LIBERTY TREE ACADEMY CONSTRUCTION DOCUMENTS

TOWN OF PEYTON, EL PASO COUNTY FINAL FOR CONSTRUCTION JUNE 2018

Add "PCD File No. PPR-18-023"
Unresolved.

SITE PLAN

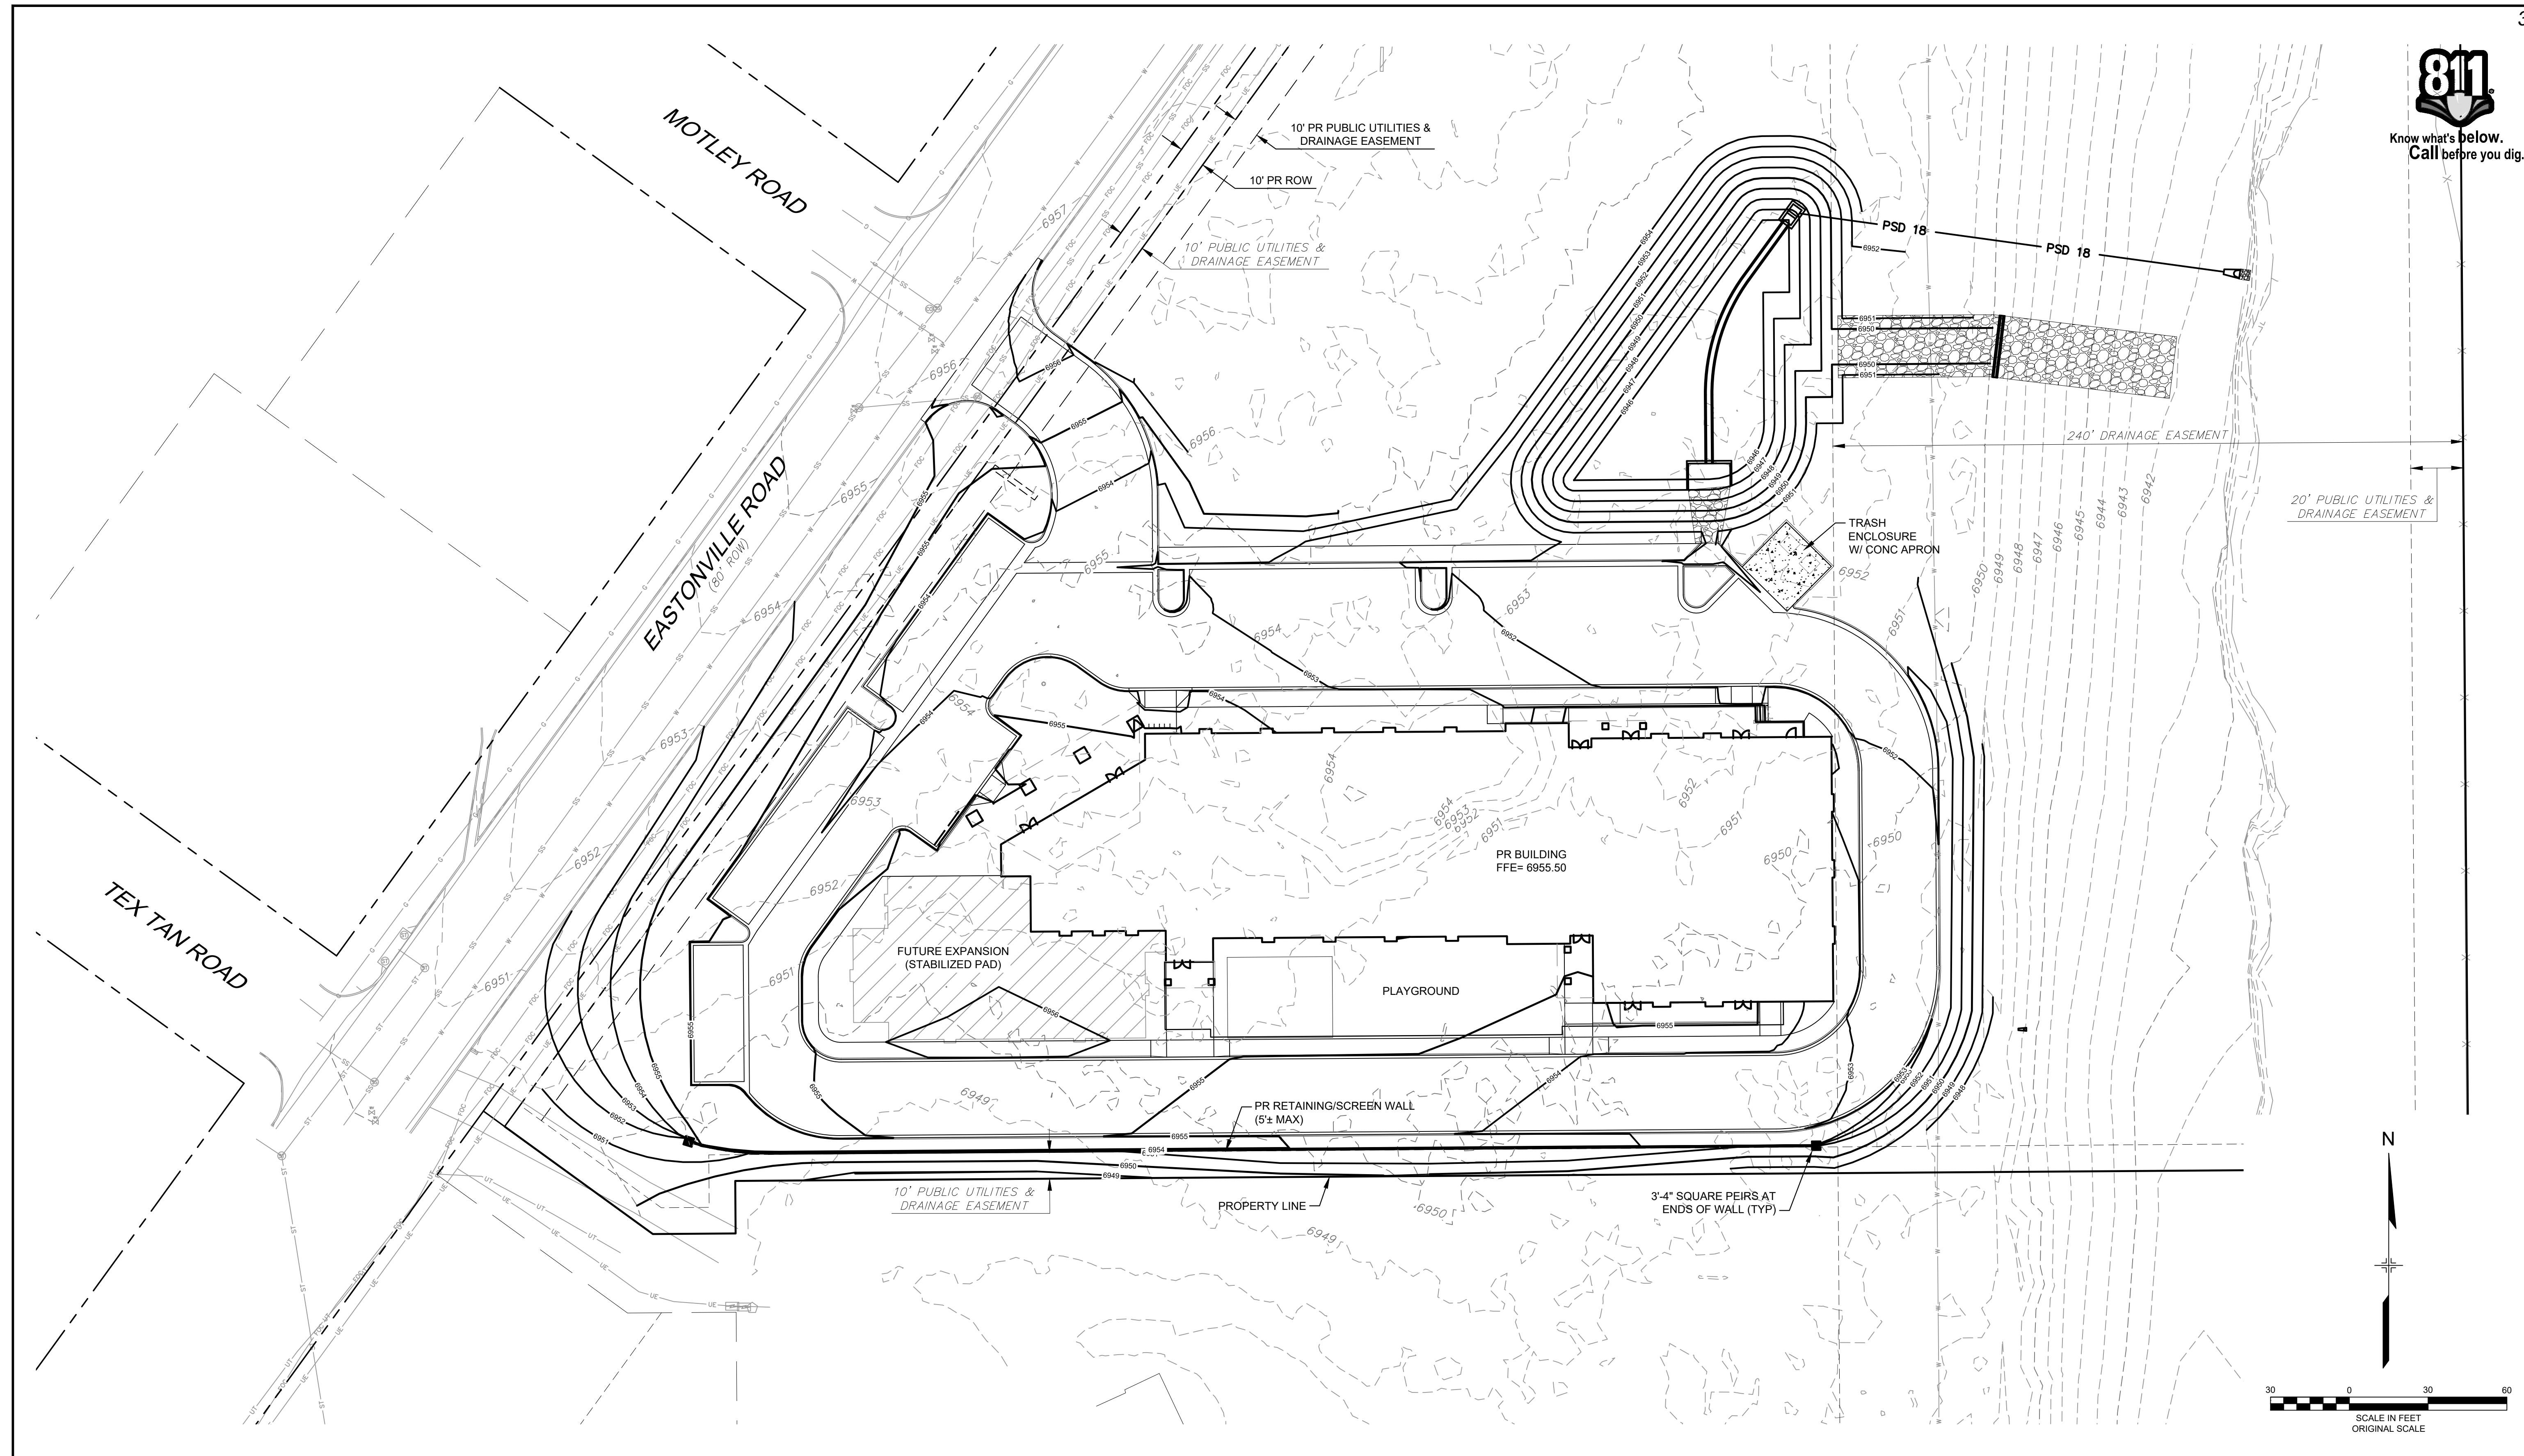
Install proposed sidewalk along the Eastonville Road frontage. See the ECM standard section for Urban Minor Arterial for the required sidewalk width and location.

Show the existing WHMD

Show how WHMD trail will cross loop or be realigned.
Unresolved
07/24/2018

Label this linework.

DESIGNED BY: ACR	SCALE: HORIZ.	DATE ISSUED: JUNE 2018	DRAWING No. GR01
DRAWN BY: ACR	SCALE: VERT.	SHEET: 3 OF 11	
CHECKED BY: DRK

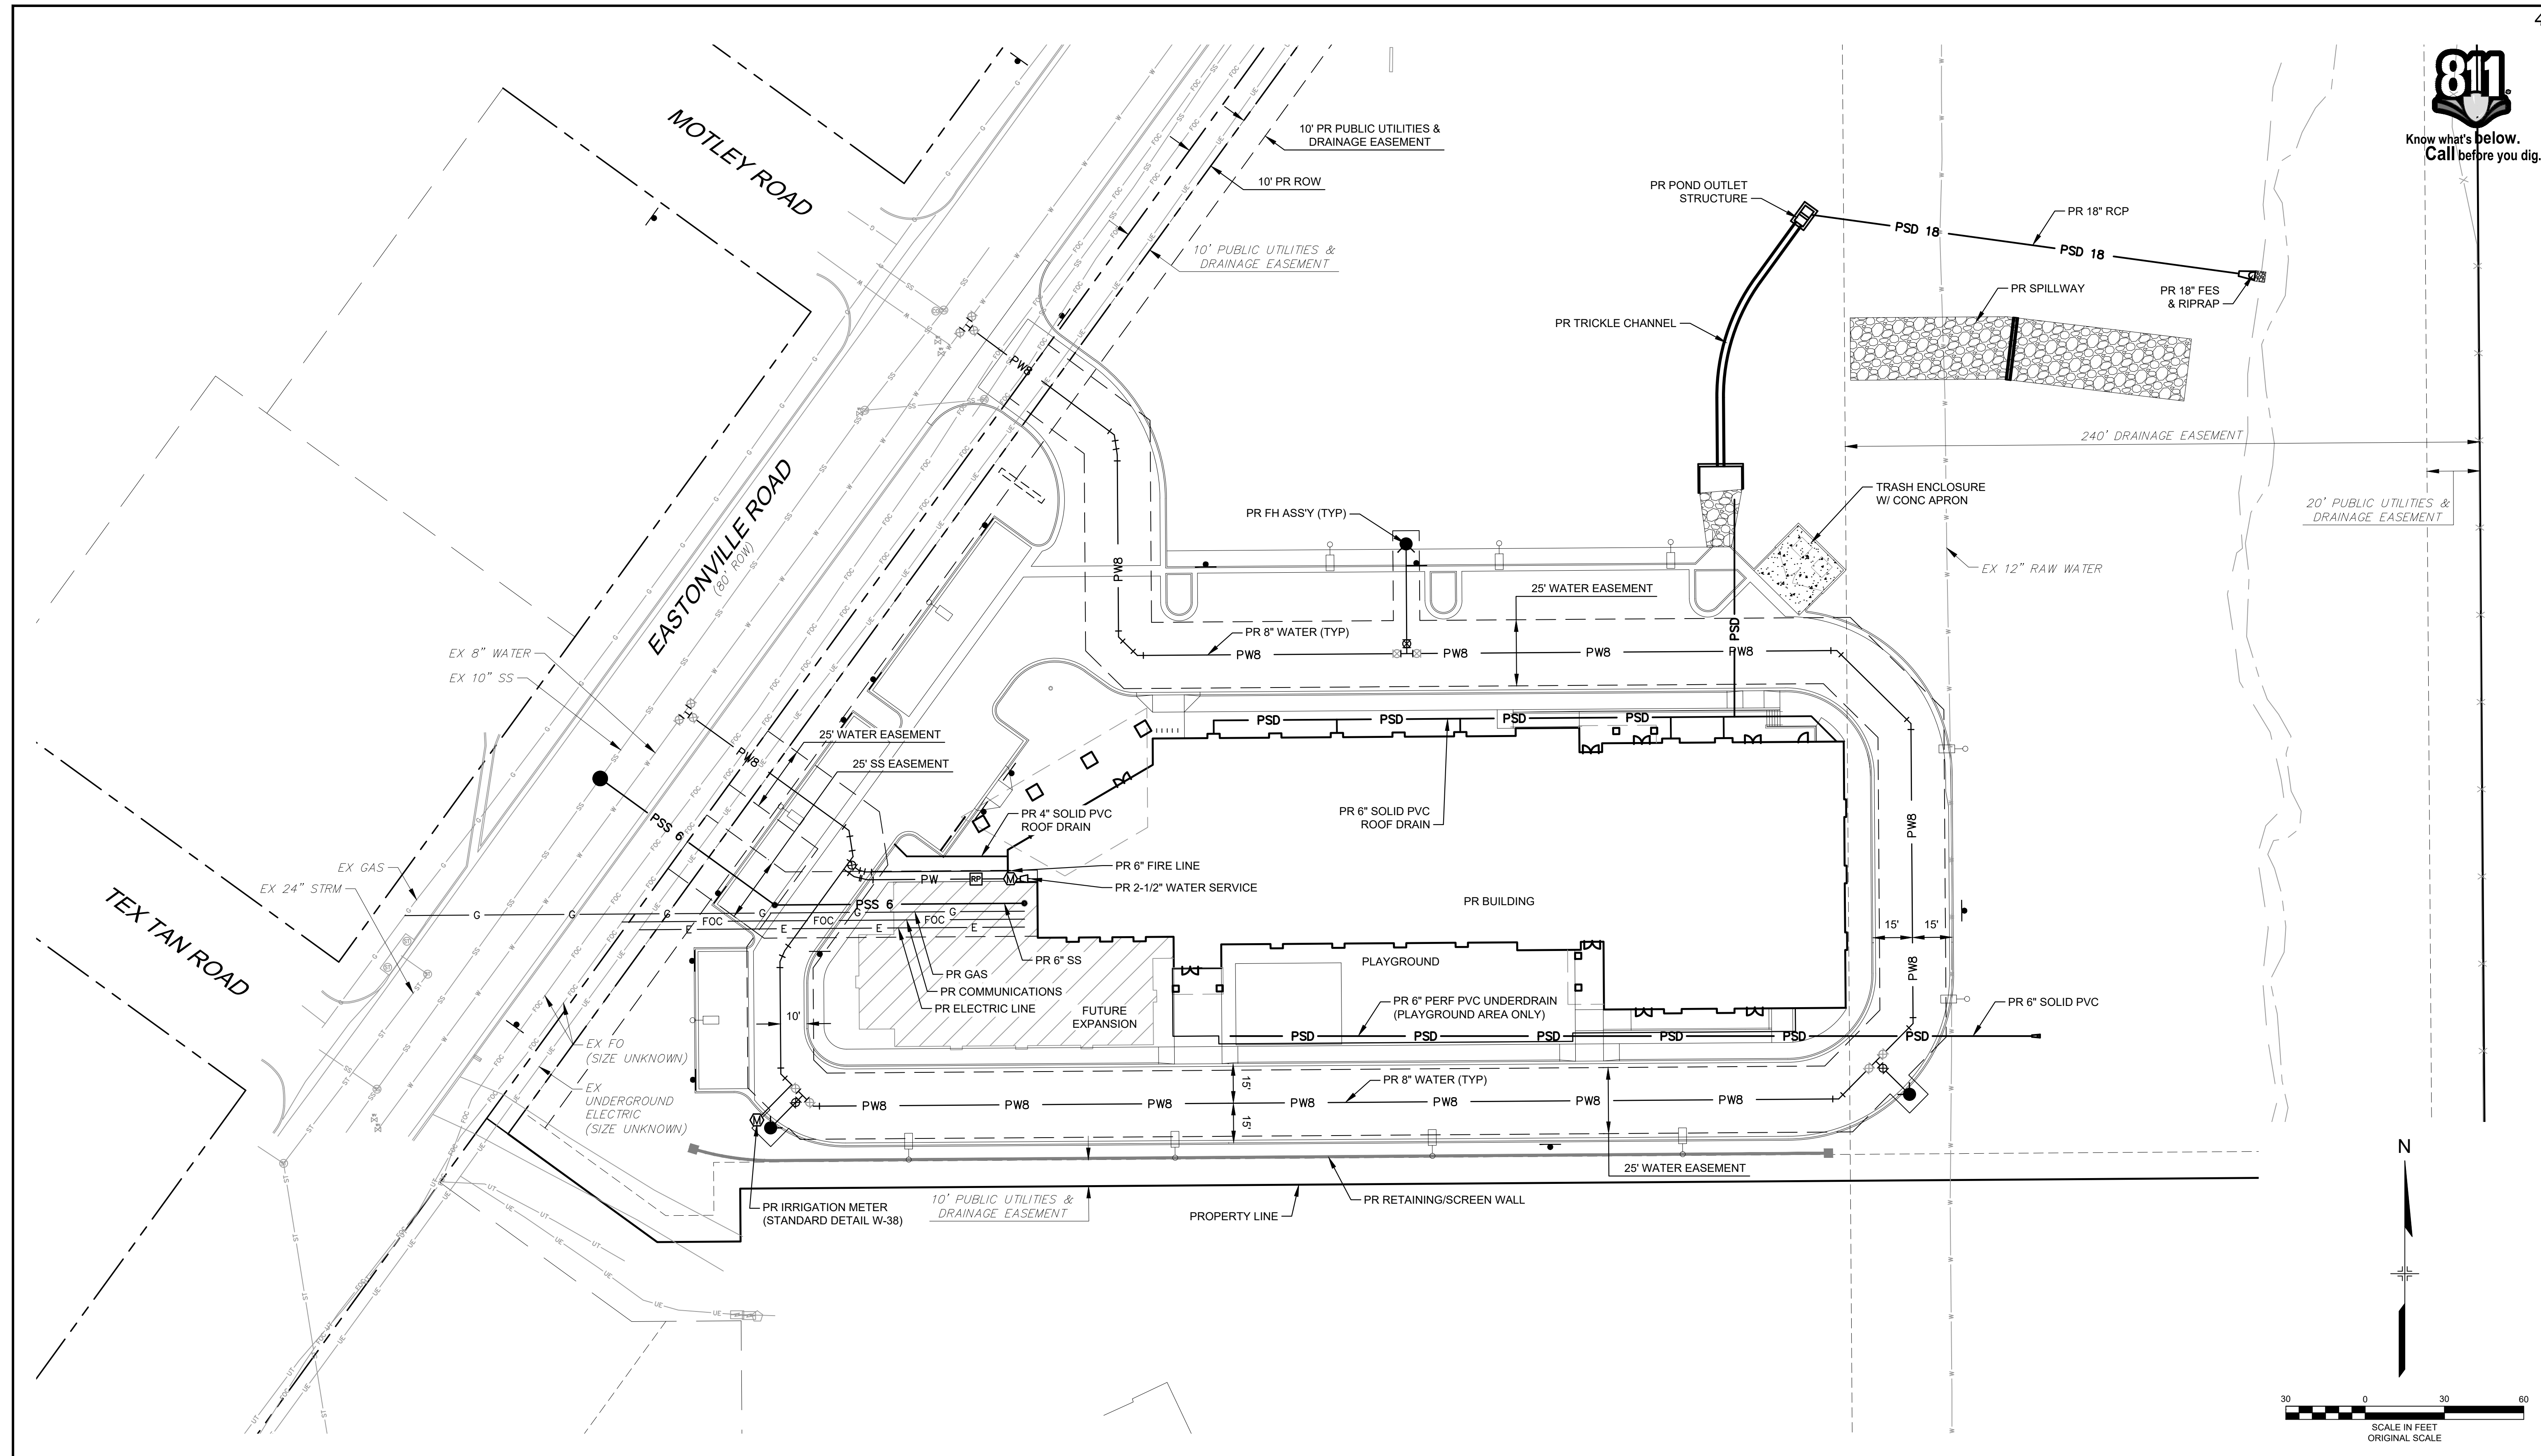
Show and label access trail (all applicable sheets).
Unresolved 07/24/2018

Show channel cross-section locations and approximate 100-year water surface and depth (all applicable plans).
Unresolved 07/24/2018

Clearly show and label existing driveway (all applicable plans). Provide documentation of correspondence with the other property owner.
Unresolved 07/24/2018

DESIGNED BY:	ACR	SCALE:	DATE ISSUED:	JUNE 2018	DRAWING No.
DRAWN BY:	ACR	HORIZ.	SHEET	4 OF 11	UT01
CHECKED BY:	DRK	VERT.

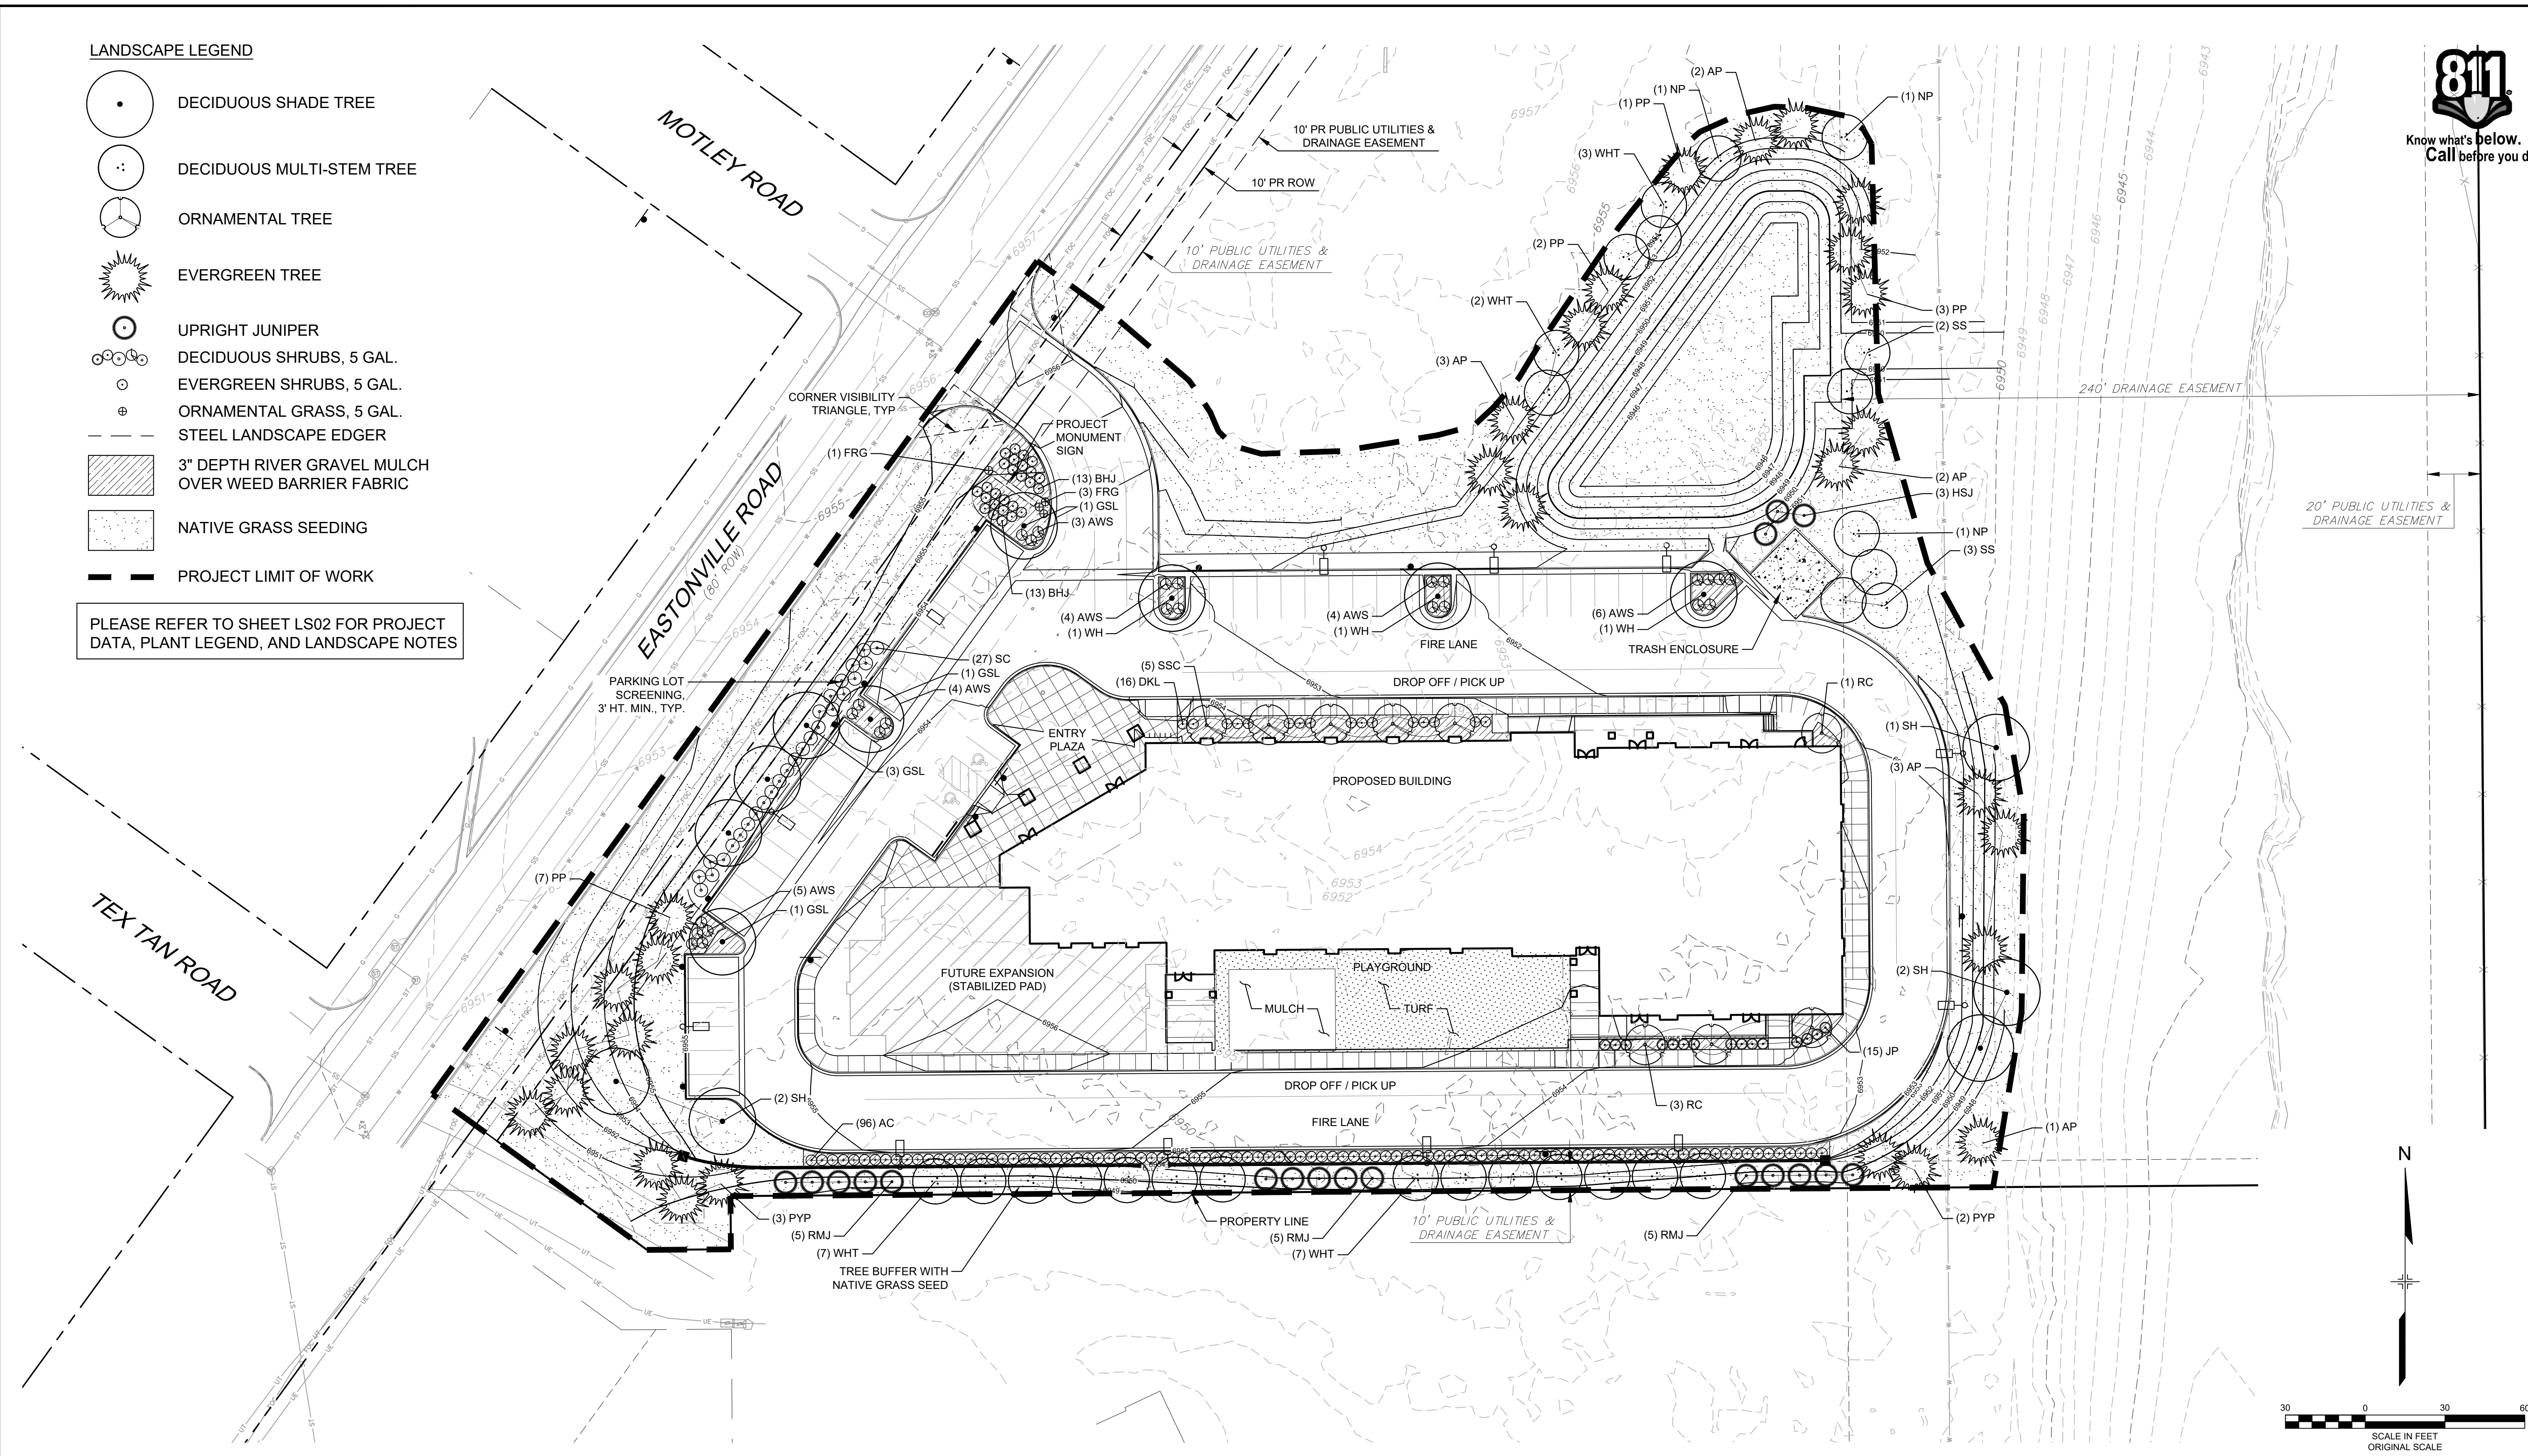
Show Diamond Shamrock pipeline also.
Unresolved 07/24/2018
